CITY OF ALBUQUERQUE

December 12, 2017

**Re: Legacy Home Healthcare
Erosion and Sediment Control Plan
Engineer's Stamp Date 12-5-17 (E12E006F)**

EROSION AND SEDIMENT CONTROL PLAN

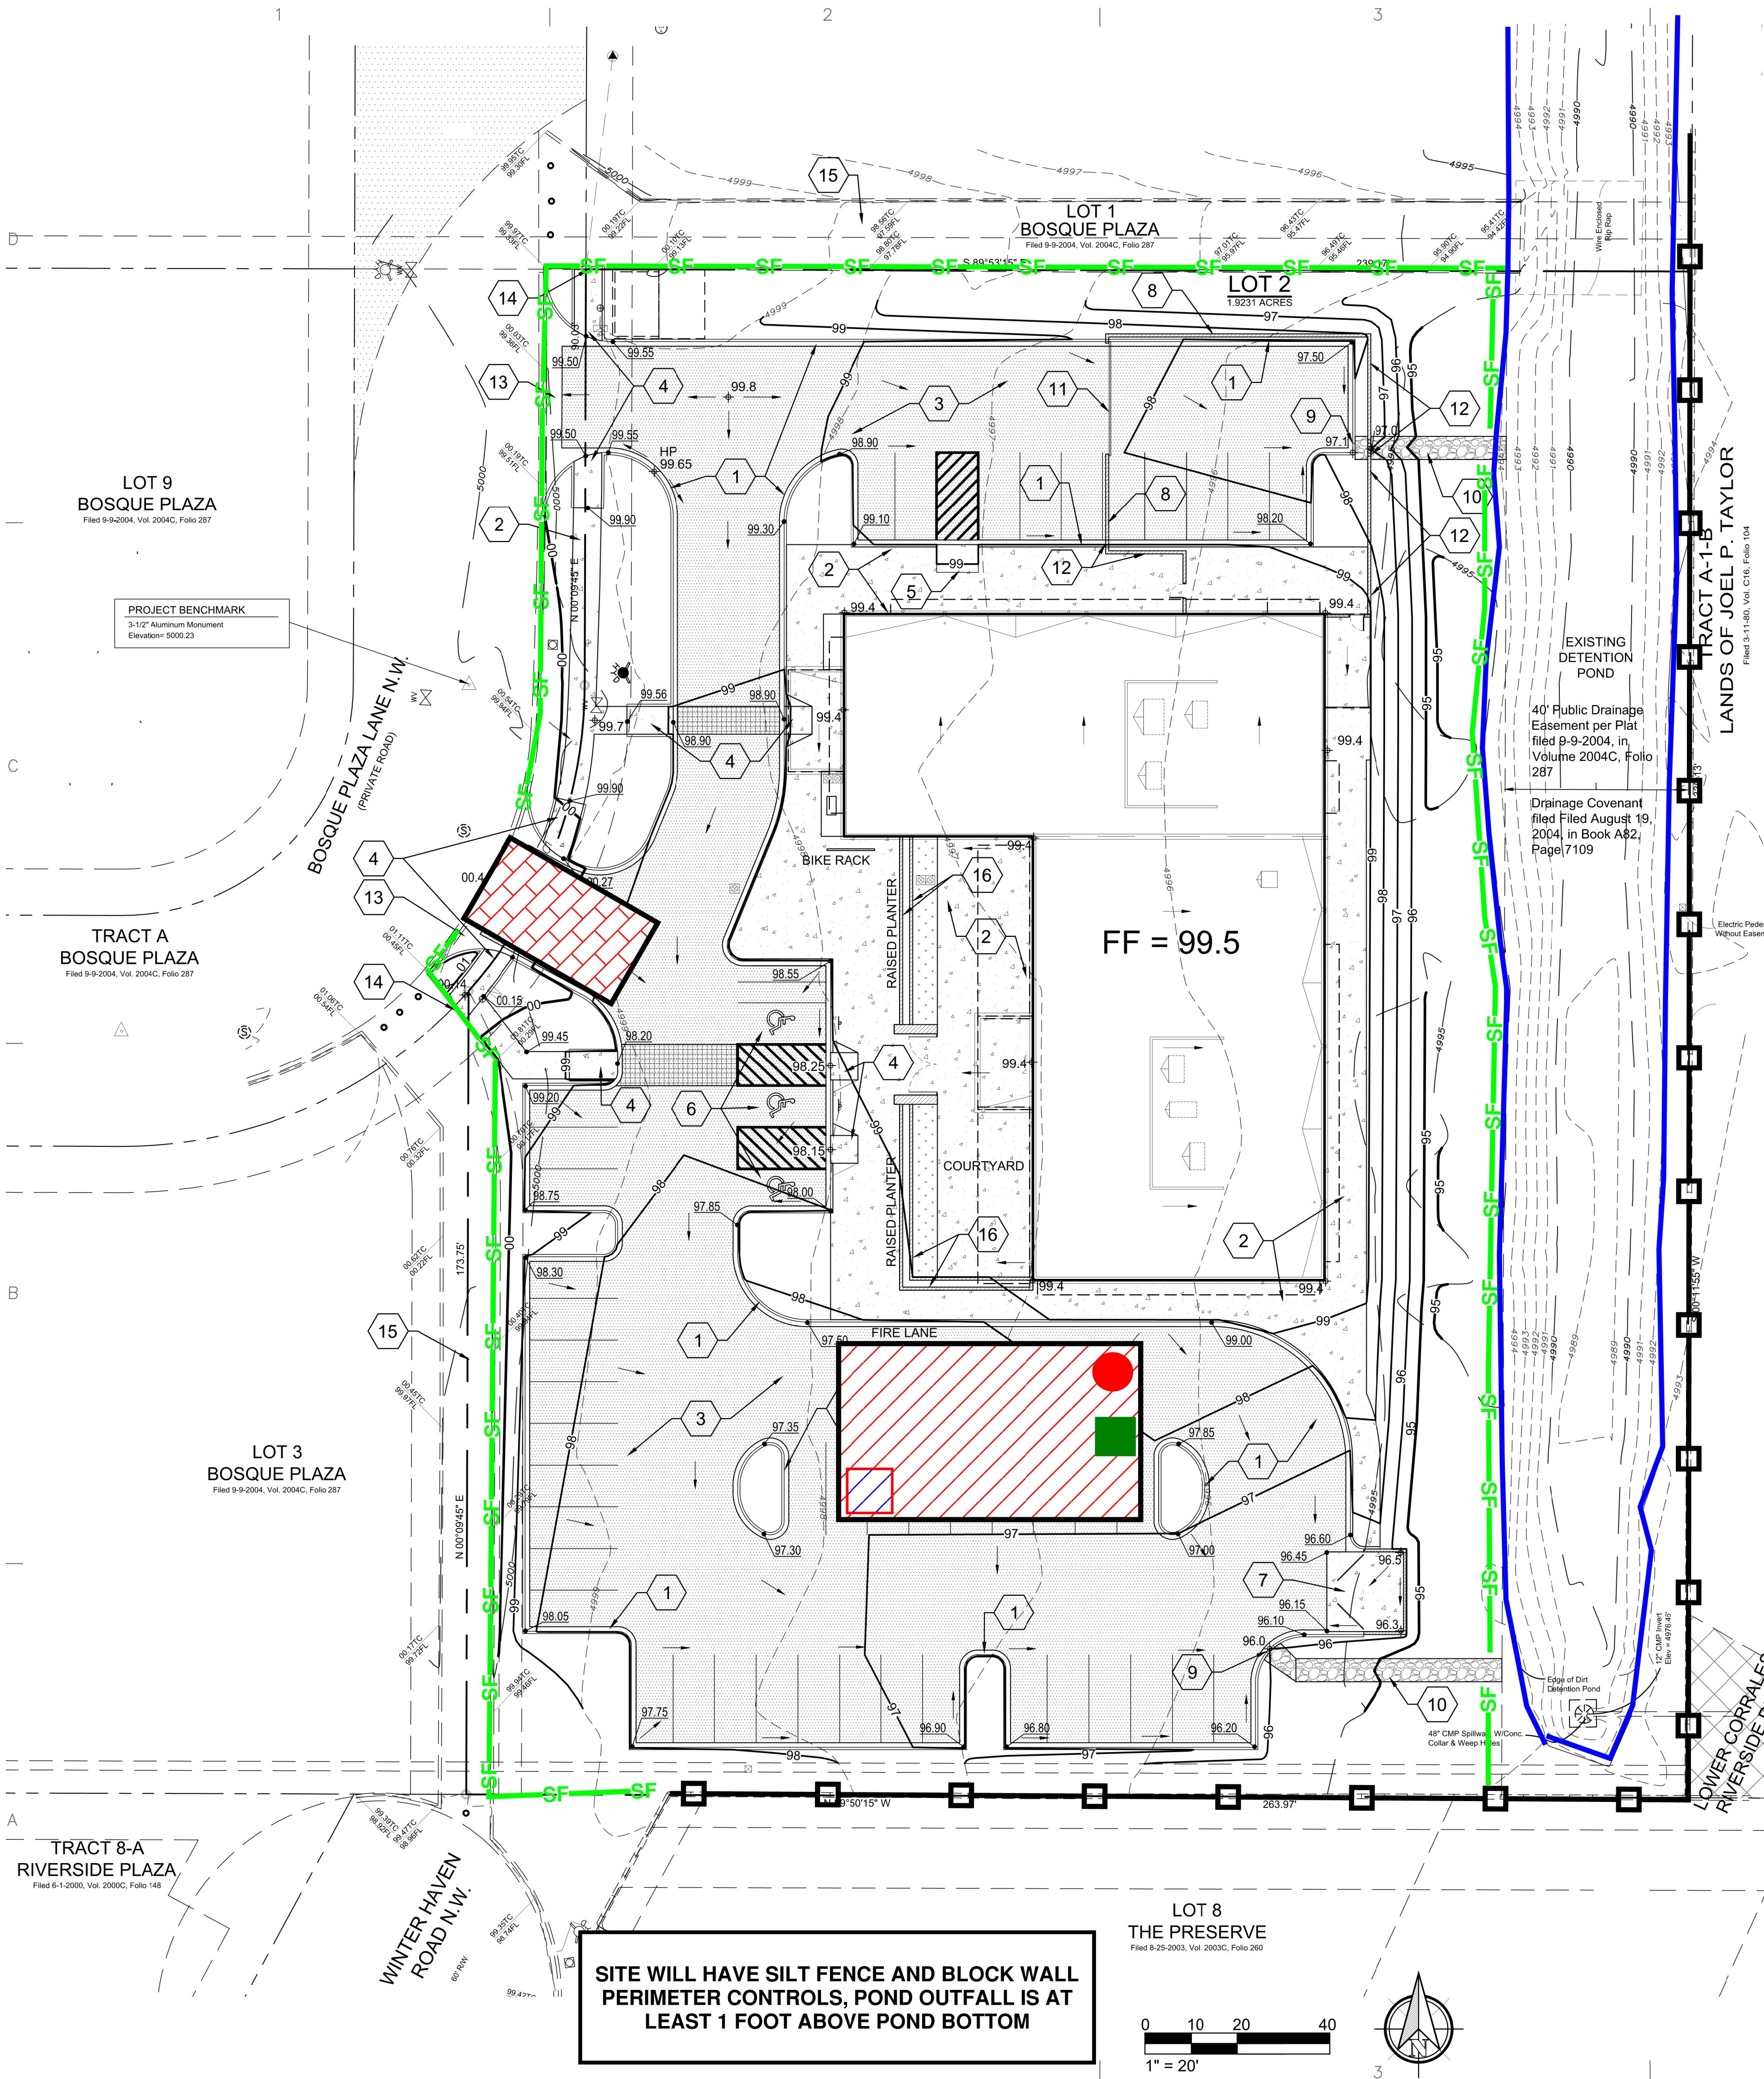
1. A sediment BMP should be proposed along the western edge of the public drainage easement located along the eastern edge of the site. It is acceptable to notch-around the riprap rundowns into the pond to provide a BMP for construction of the rundowns. Sediment and construction site wastes should be kept out of the pond.
2. Please remove the proposed inlet protection for the pond outlet structure. It appears the lowest row of holes in the outlet structure is a minimum of 1 foot above pond bottom.
